PLANNING PORTAL SUBMISSION REF: PP-13635662
LAND OFF, CROSSLEY LANE, COLD ROYD LANE & ALBANY ROAD, DALTON, HUDDERSFIELD

JRP are instructed on behalf of Crest Nicholson to submit a non-material amendment (NMA) under section 96A of the Town and Country Planning Act 1990, for the following permission:

This NMA relates to the following amendments for plots A37 to 58:

DRAWING NUMBER:
23-5666-5026-B

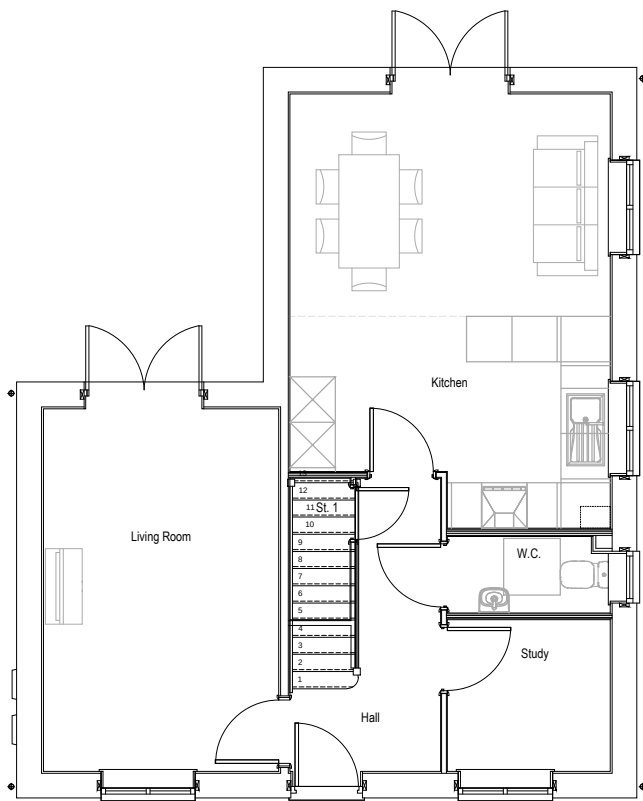
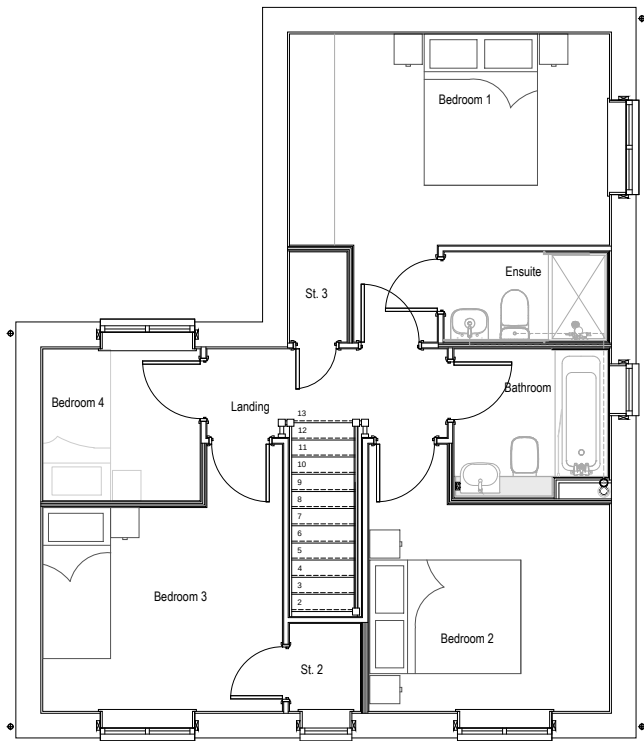
- Layout
 - Plot A46 garage pushed back
 - Plots A47 & A50 garage pushed back
 - Plots A48 & A49 garage removed, and plots pushed back
 - Plot A52 garage pushed back
 - Plots A51 to A57 garages removed
 - Plot A58 garage pushed back
- Elevations
 - Type F – Minor revisions including glazing bars, heads and cills, door canopy and PV panels added
 - Type G – Minor revisions including glazing bars, heads and cills, door canopy, dentil detailing and chimney removed, and PV panels added
 - Type P - Minor revisions including glazing bars, heads and cills, door canopy, dentil detailing and chimney removed, bay window and PV panels added
